Submitted by hand today by Mr & Mrs Pilfold
South Norris 125 North Lane East Preston BN16 1HB

**OBJECTIONS TO PLANNING APPLICATION EP/57/21/ PL
LAND TO REAR OF BEECHLAND "COTTAGES"/ NORTHERN PARADE OF SHOPS
EAST PRESTON**

Elevations of new stircase to existing building

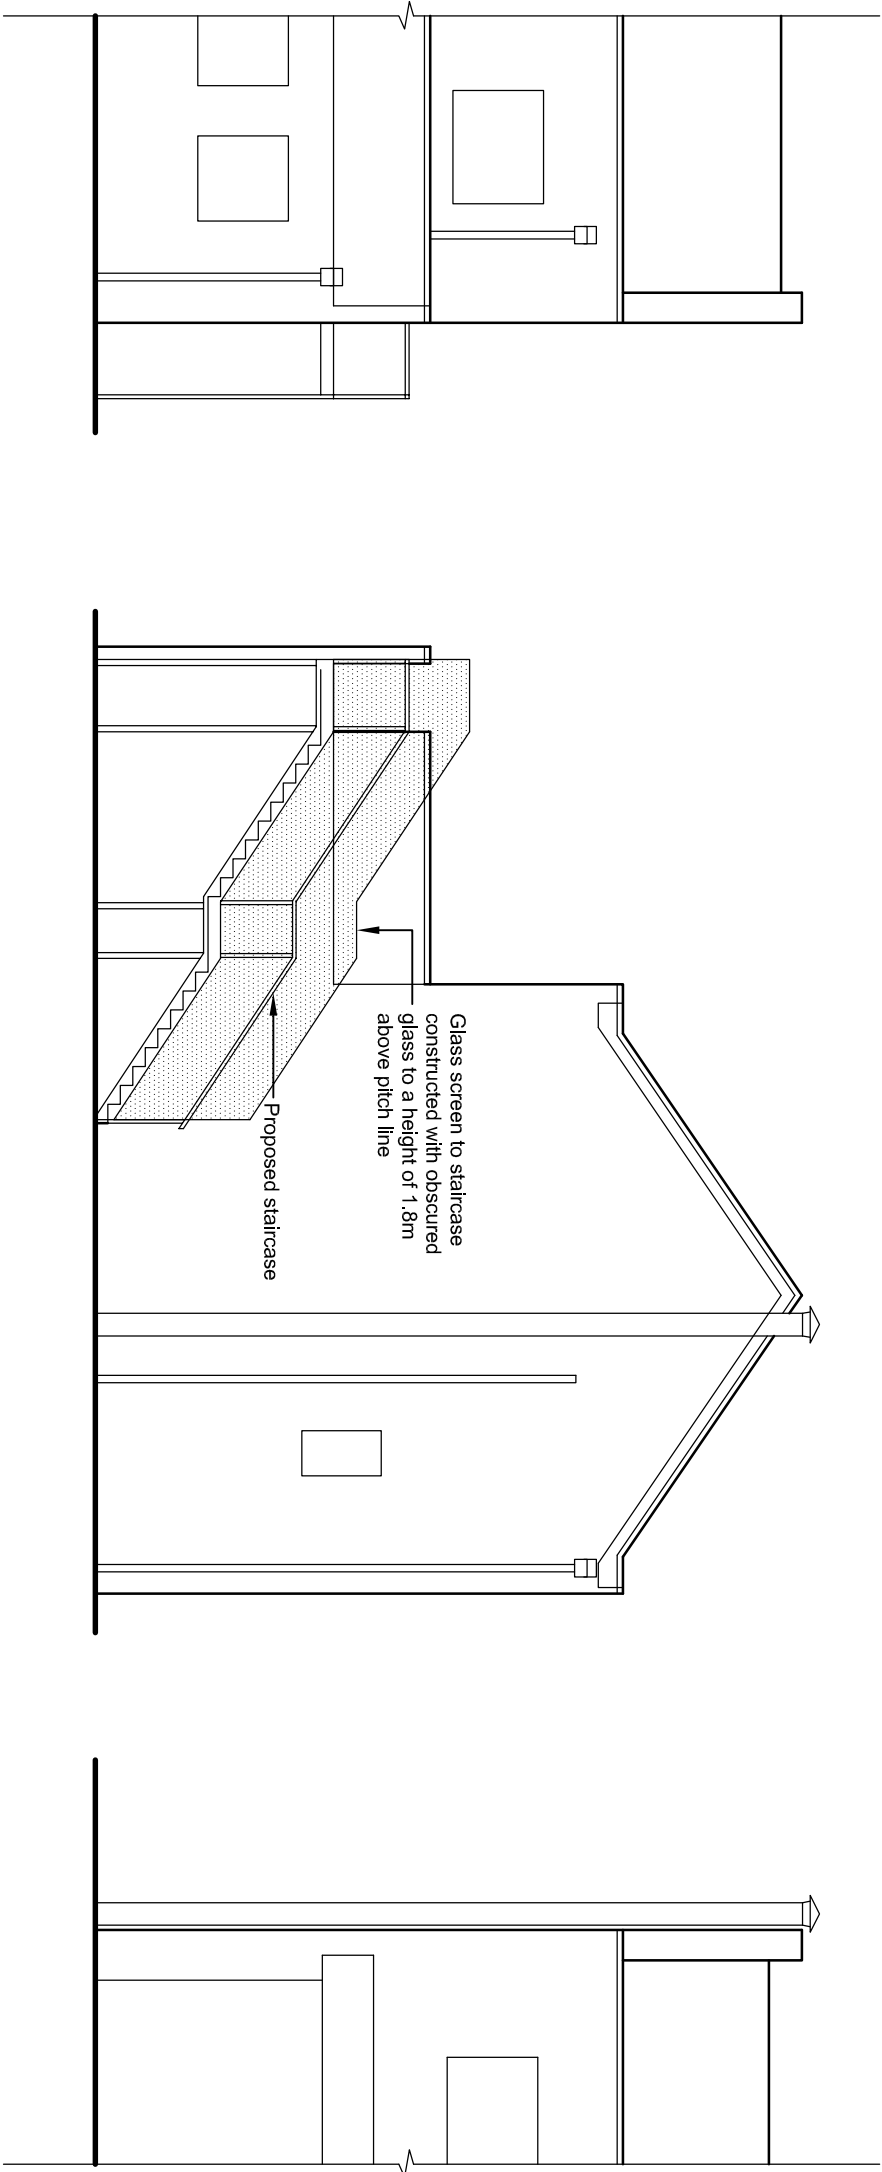
Re-positioning of the metal staircase to the Northern end of the existing balcony at the rear of the flats would be unsightly and intrusive being only **3.2 metres** away it would interfere with our privacy as it's proposed position will be adjacent to our conservatory / dining area and open for use to anyone and everyone .

As an escape route it would require the unlocking of the inward opening gate at the end of the alleyway which has been closed until recently to all since the mid-eighties

The gate should open out not in and have an efficient controlled device to prevent it being left open for access by all and sundry, panic bars are designed for internal doors and do not close gates.

The proposal now is to place this escape route on the northern end of the balcony **34m away** from these two dwellings with no other means to access the ground safely, this leaves the two families with young children occupying the flats in a hazardous situation. Washing lines are strung across the balcony inhibiting escape as the landlords have used their gardens to build on previously EP/49/10/DOC (Beechlands Cottages)

We cannot understand how in this age of Health& Safety why anyone would consider relocating an emergency Fire Escape over a Fish and chip shop with its deep fat fryers 34 metres from two of the flats across an asphalt roof

DRAWING TITLE:
Proposed Plans and Elevations

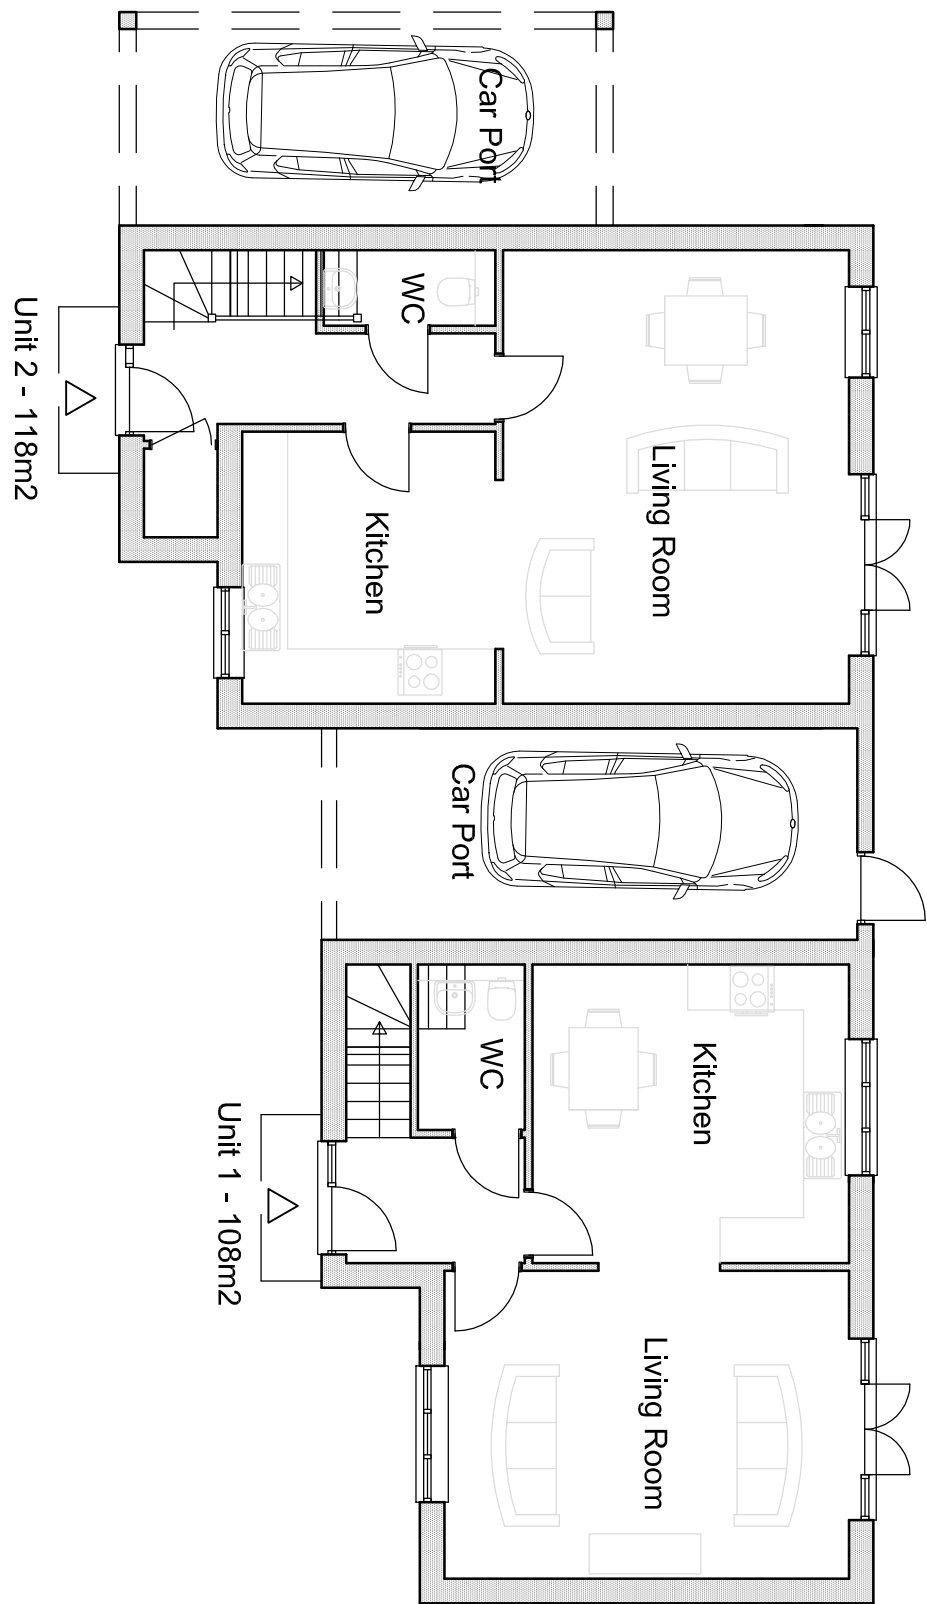
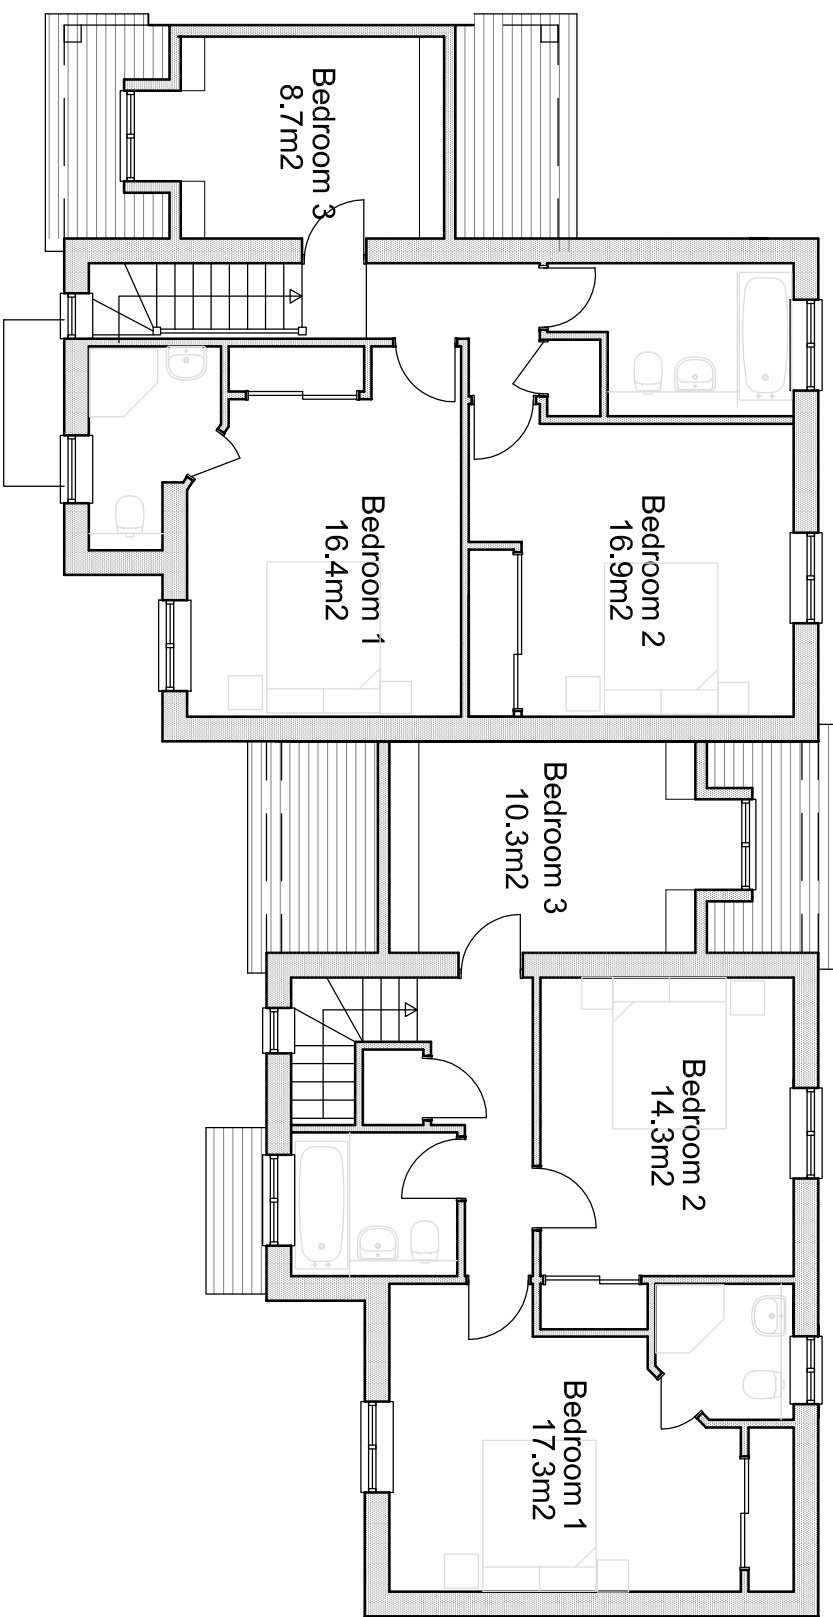
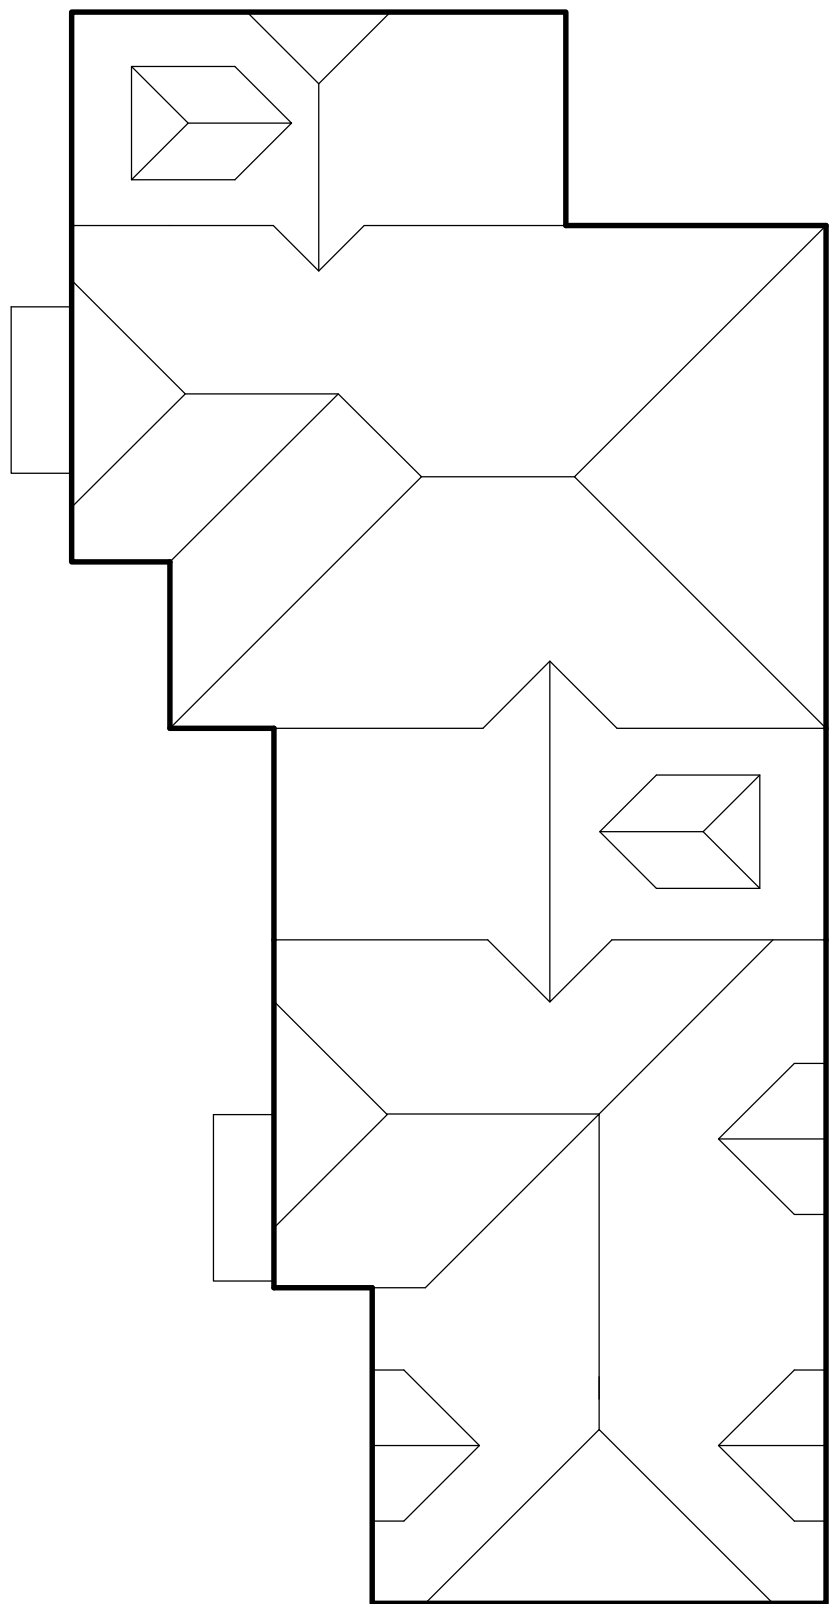
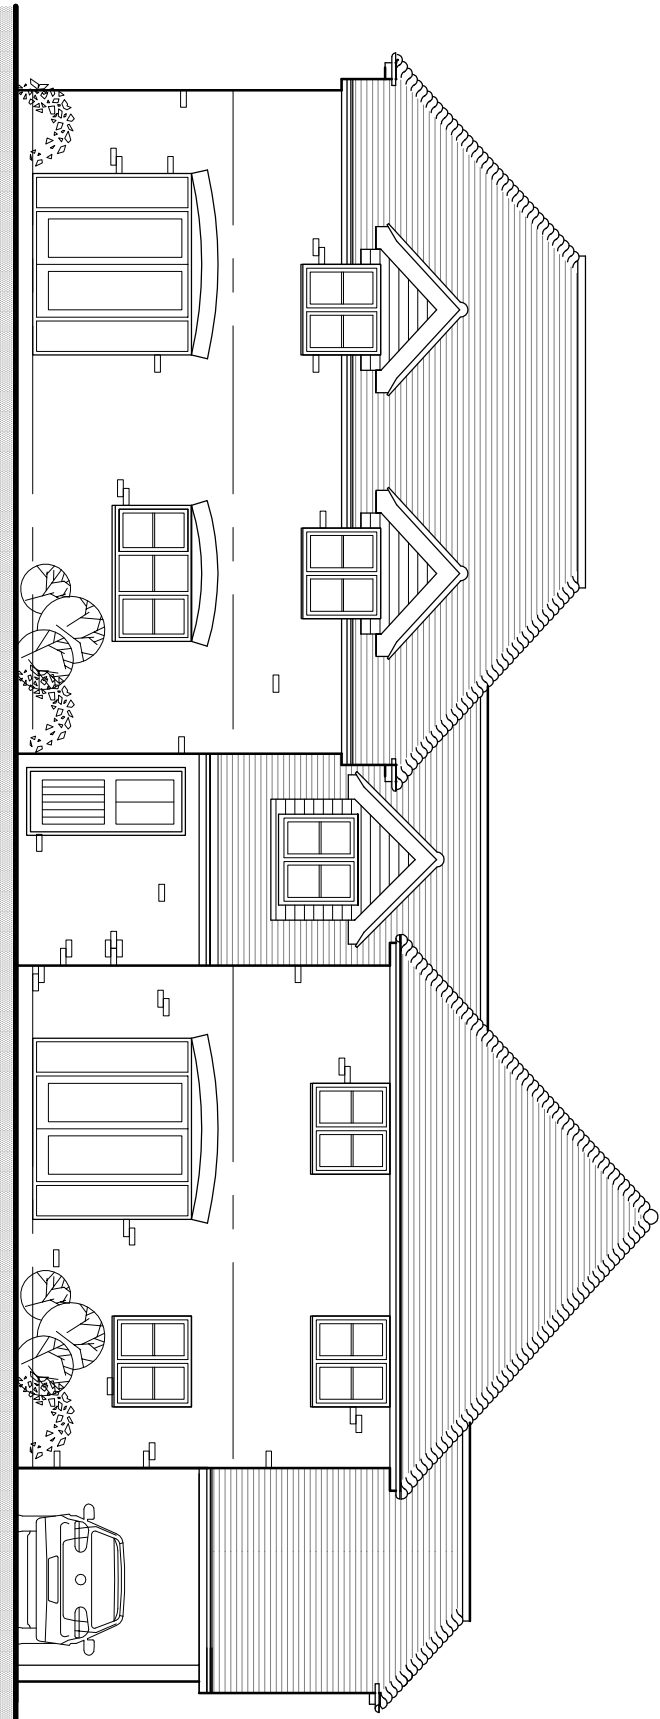
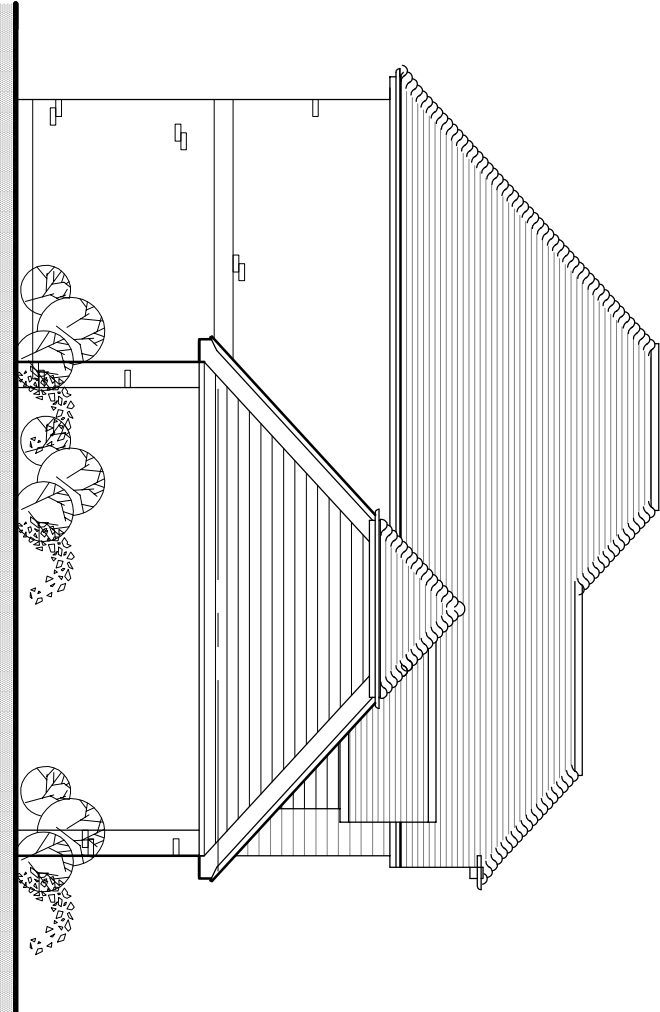
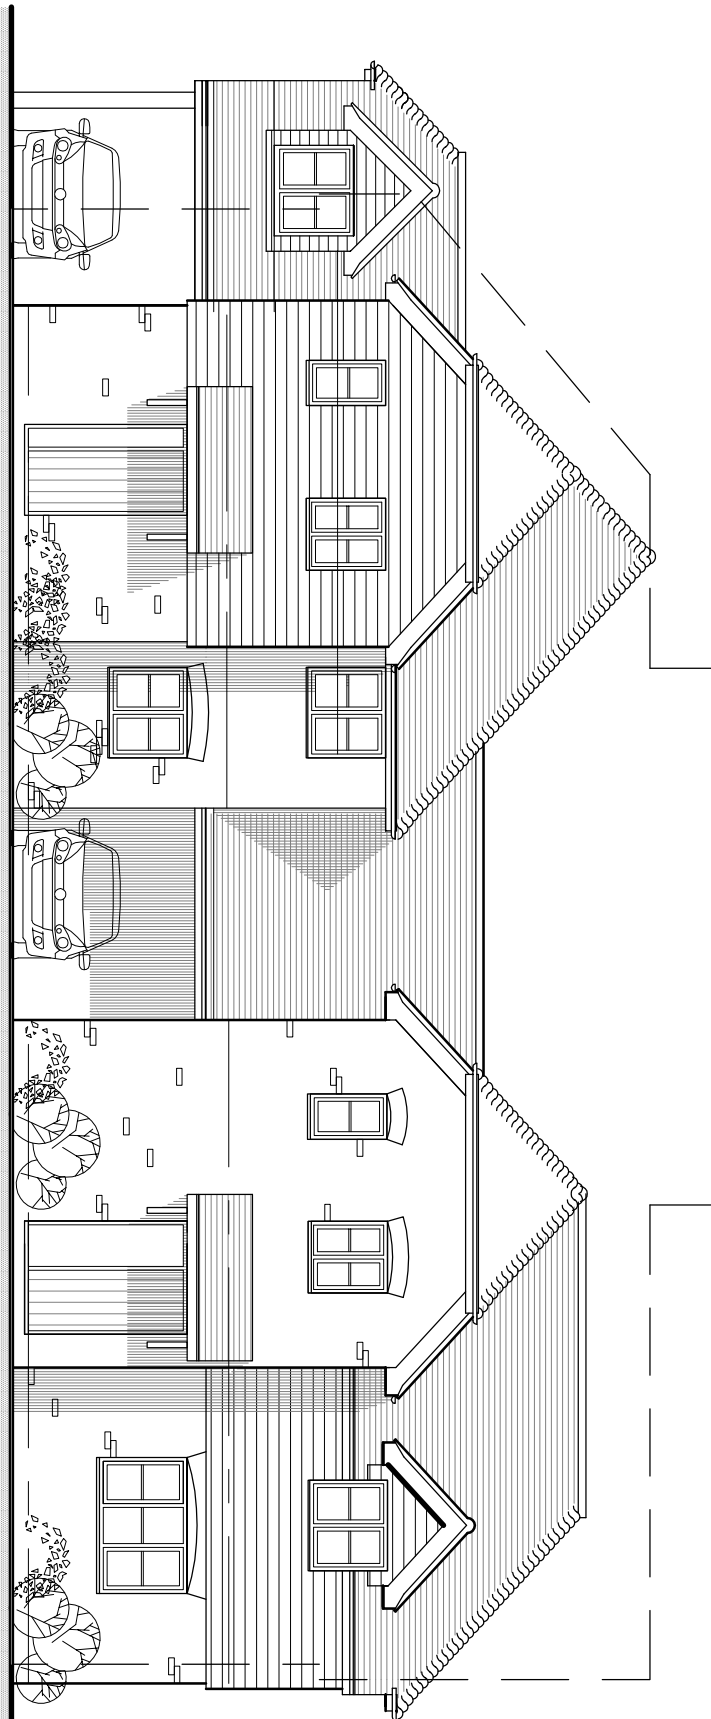
At almost 9 metres to the ridge line the design and height of the proposed dwellings will cast a shadow on our garden and severely restrict any sun particularly from sunrise to midday during the winter months when it is at its lowest.

The design and height will have an overbearing and intrusive impact on us by allowing an invasion of our privacy, considerably reducing the enjoyment of our property.

The occupants of these proposed dwellings will have a clear view into our property if they are built, their views would be further enhanced by the reduction in the height of our existing 2.7 metre high boundary wall forming the back of the 'to be' demolished garages. The substantial wall on removal to be replaced by an 1.80m high wooden fence on the plans.

The carports are far to narrow for any passengers other than escape artists to exit the vehicles
